Director of Development Services
Ribble Valley Borough Council
Council Offices
Church Walk
Clitheroe BB7 2RA

Martin Nugent
01254 828060
D3/12/0913

**Outline Planning Application, Ribble Valley District
D3-12-0913 Waddow View, land off Waddington Road, Clitheroe**

Proposed Buses Only Road for the Waddow View site

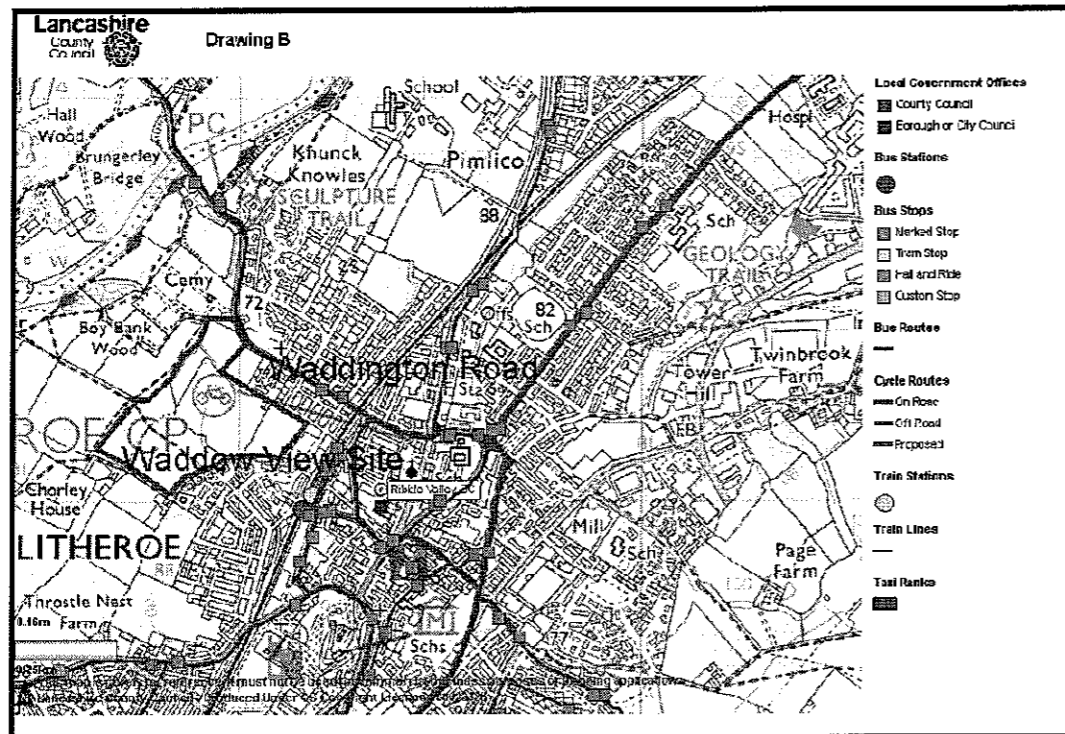
The Applicant has identified two possible routes for bus services that would provide significant penetration into the development, linking both aspects of the site from Waddington Road through to Kirkmoor Road.

The route WV1 would be preferable, as WV2 would take the scheduled service via Milton Avenue, a road which supports on street residential parking to properties with no off street provisions.

Finally for capacity purposes the Waddington Road/Railway View junction has been improved with a mini roundabout arrangement.

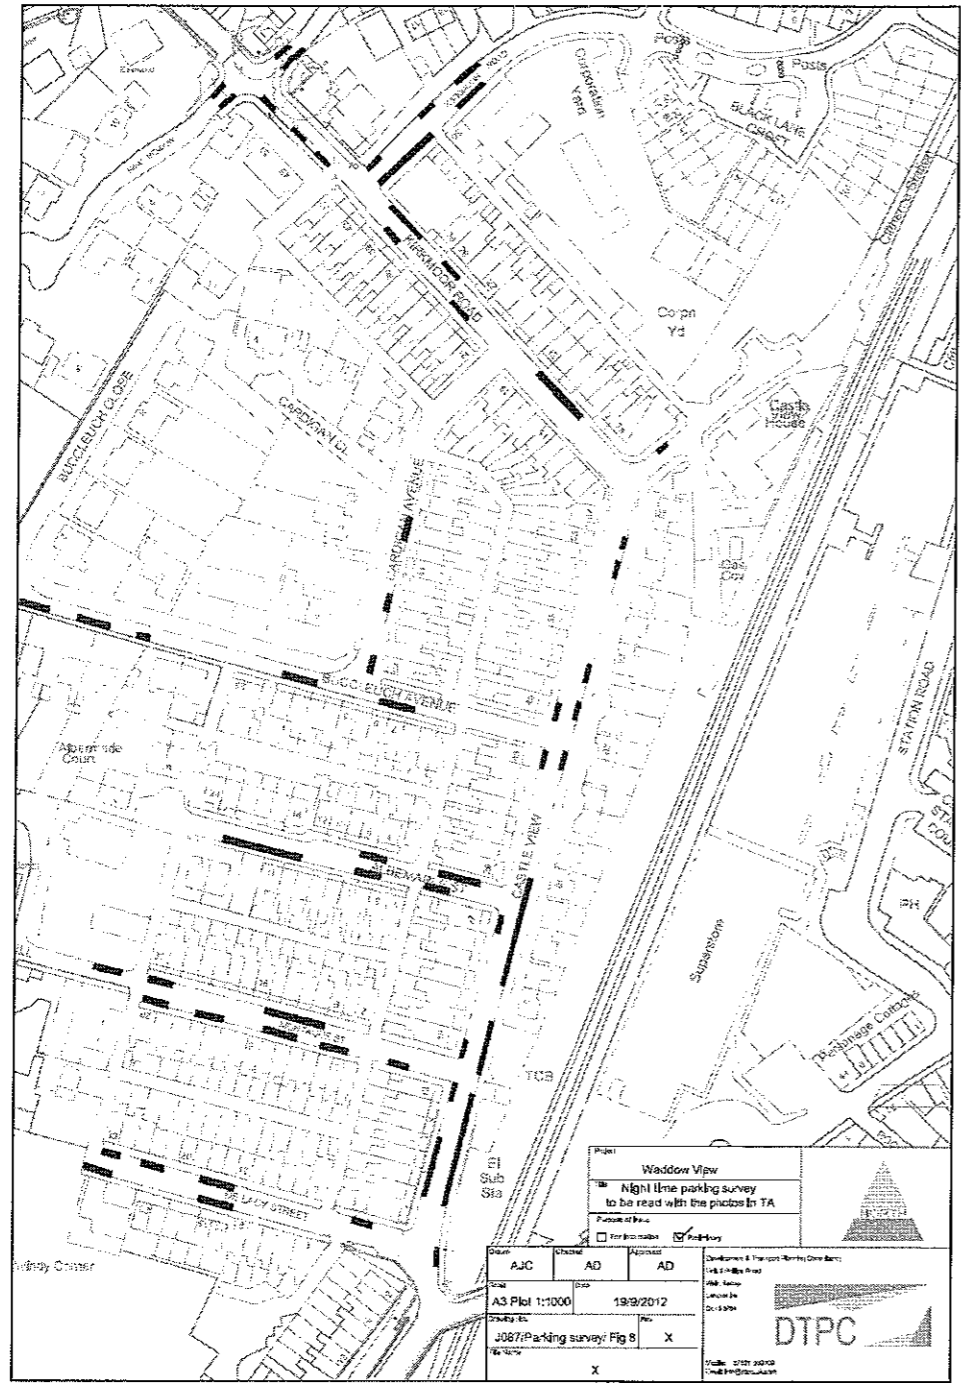
Taking first the proposed mini-roundabout at Railway View Road, the decision to pursue this design may reflect changes in the balance of movements through the junction. There is sufficient width within the available highway to accommodate this design and there could be benefits in the improved circulation of vehicles and the potential capacity of the junction.

However, there remain physical limitations to such a design, most notably the positioning of the central dome and the restricted width of the approach from Waddington Road on account of the rail bridge structure.

That said, subject to further discussions on the detailed design of the junction and its immediate approaches, I have no objection on principle to the suggested junction arrangements.

NEW TRAFFIC SIGNALS AHEAD

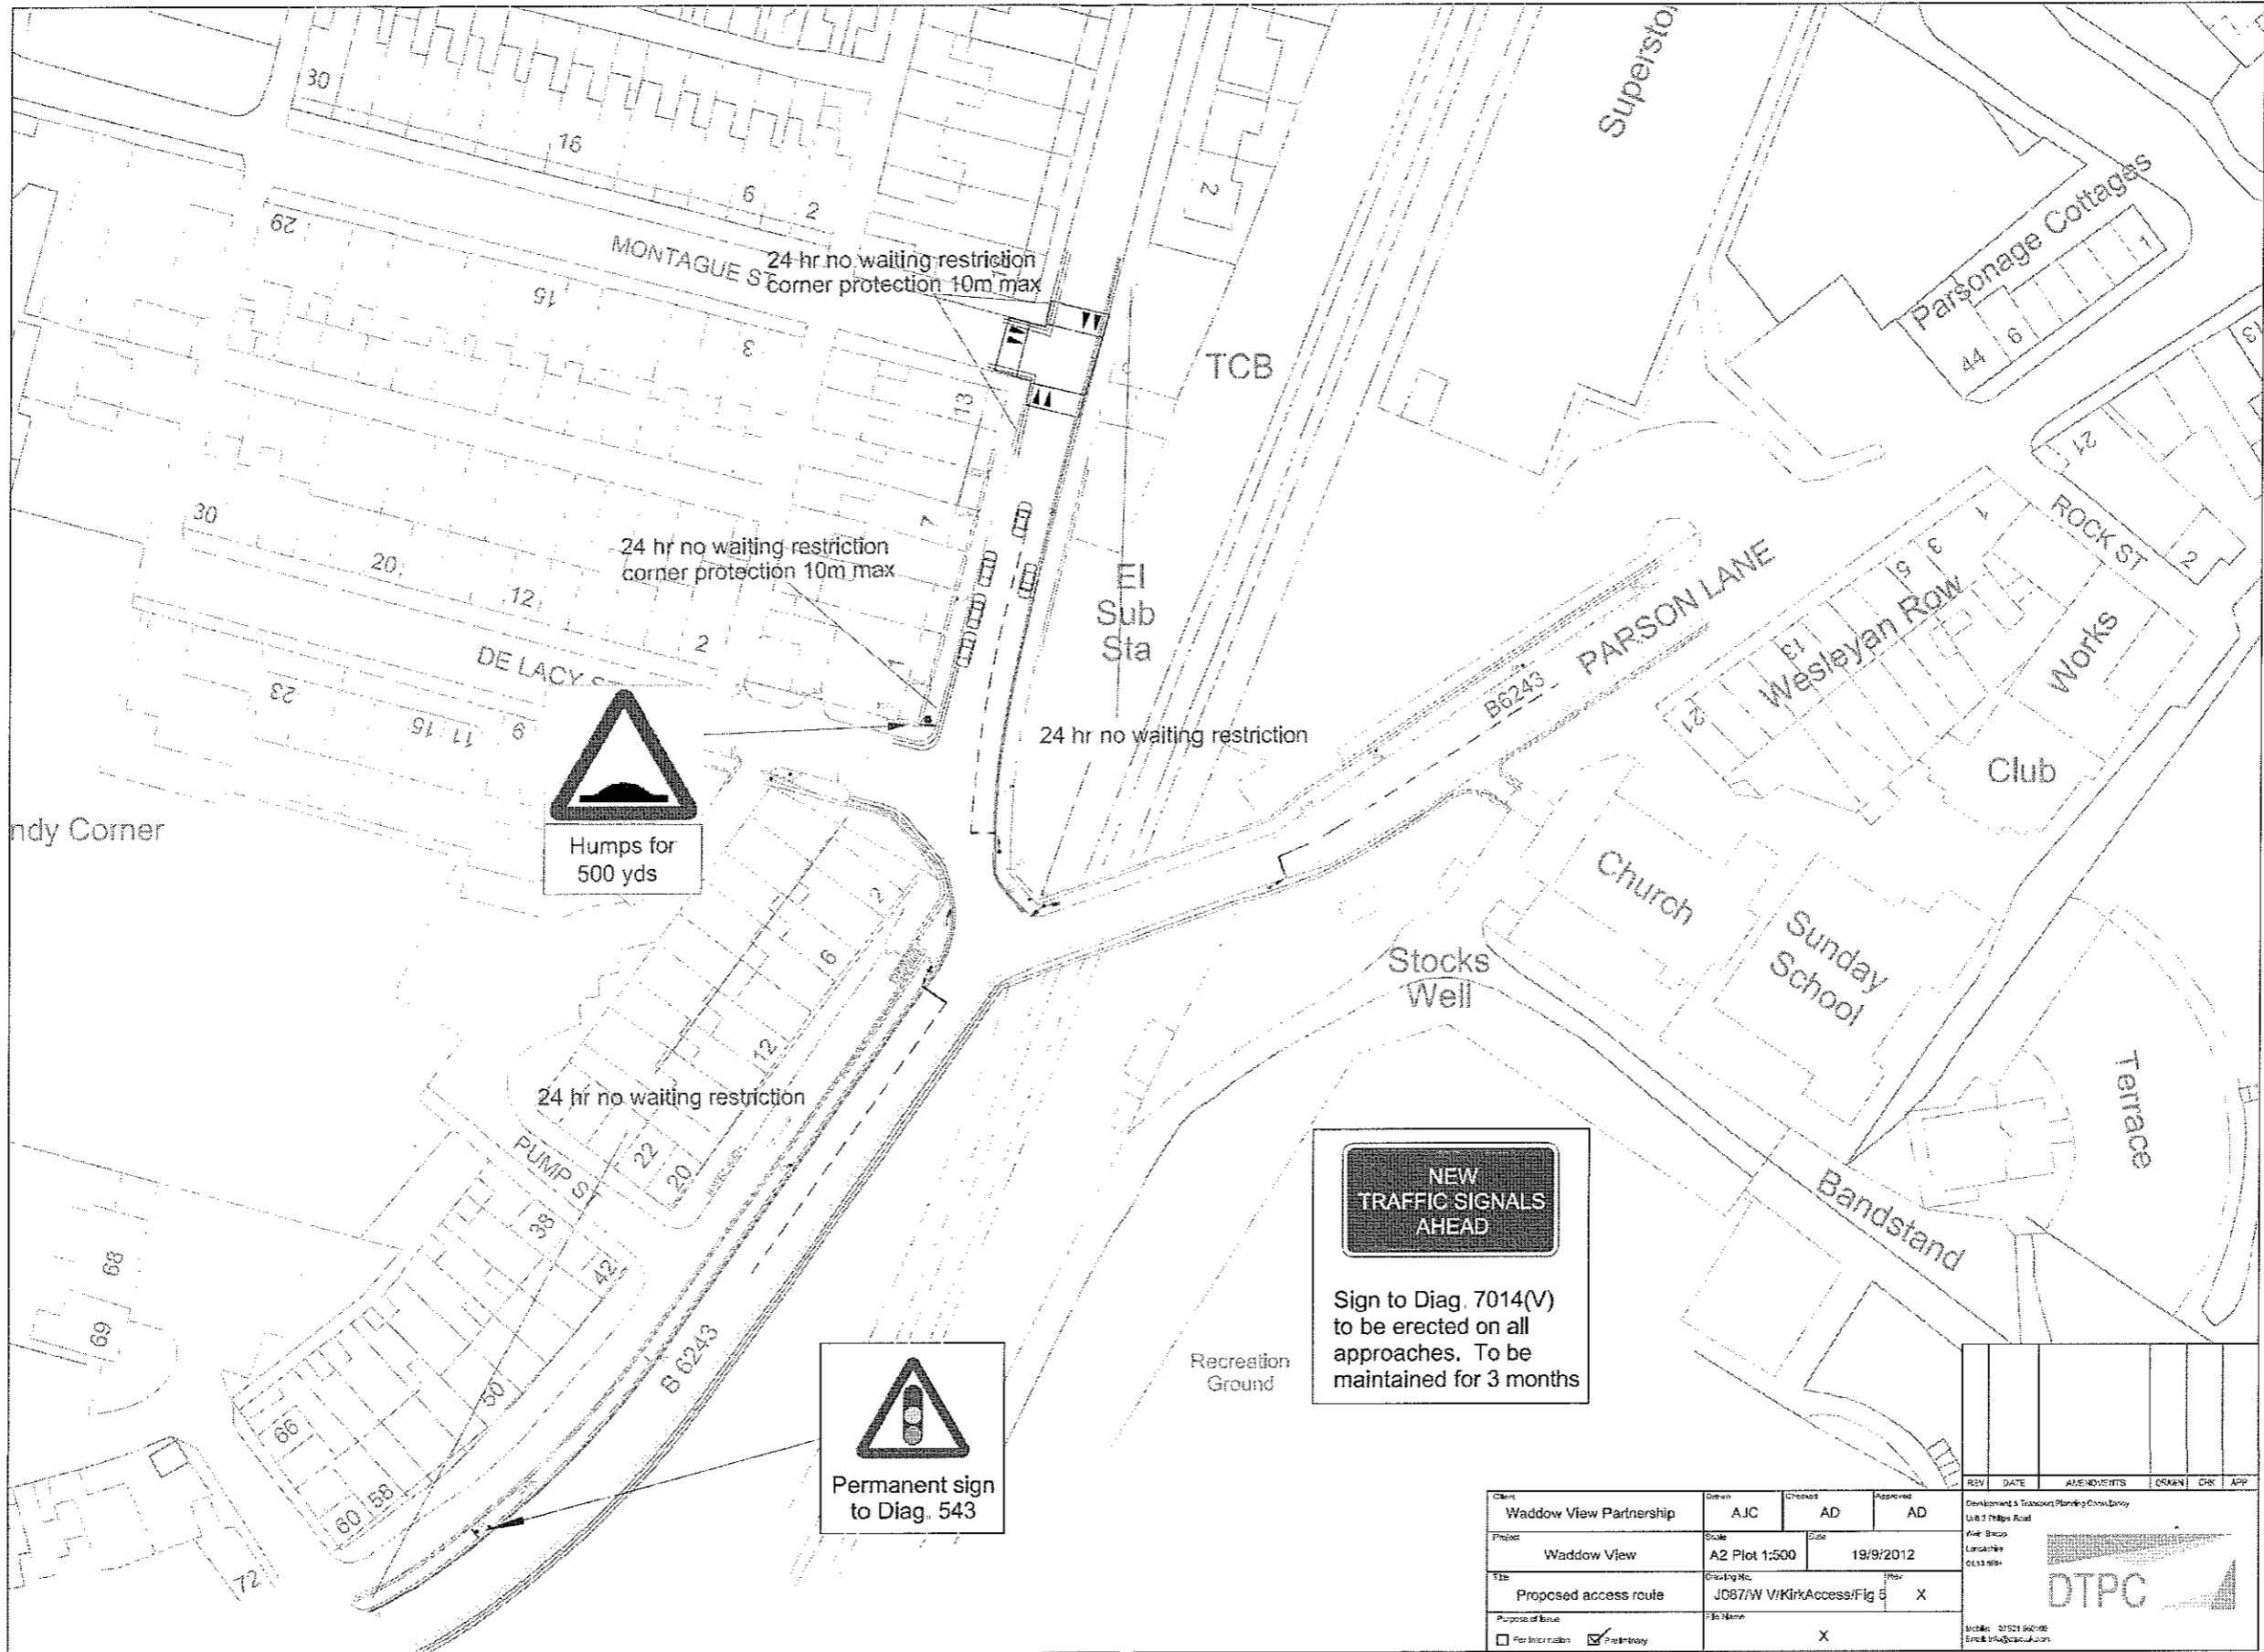
Therefore, the intention to introduce signal control is based on addressing potential highway safety issues with conflicting movements at the junction and across the bridge.

With the signals, the OSCADY modelling anticipates that there will be in excess of 11 vehicles queuing on Parson Lane during the PM peak hour. At this level, the stationary traffic begins to impact on free flow movements due to the existing on street parking demands of residents at Wesleyan Row and movements to and from the service access to Booths supermarket.

This is a highly sensitive location as it is the main route out of Clitheroe for a number of villages to the west of the District and for a number of convenient highway links to the principal road network. I appreciate that the phasing and detailed software programmes may allow for effective revisions of the OSCADY projections and further discussions on this matter would be welcomed.
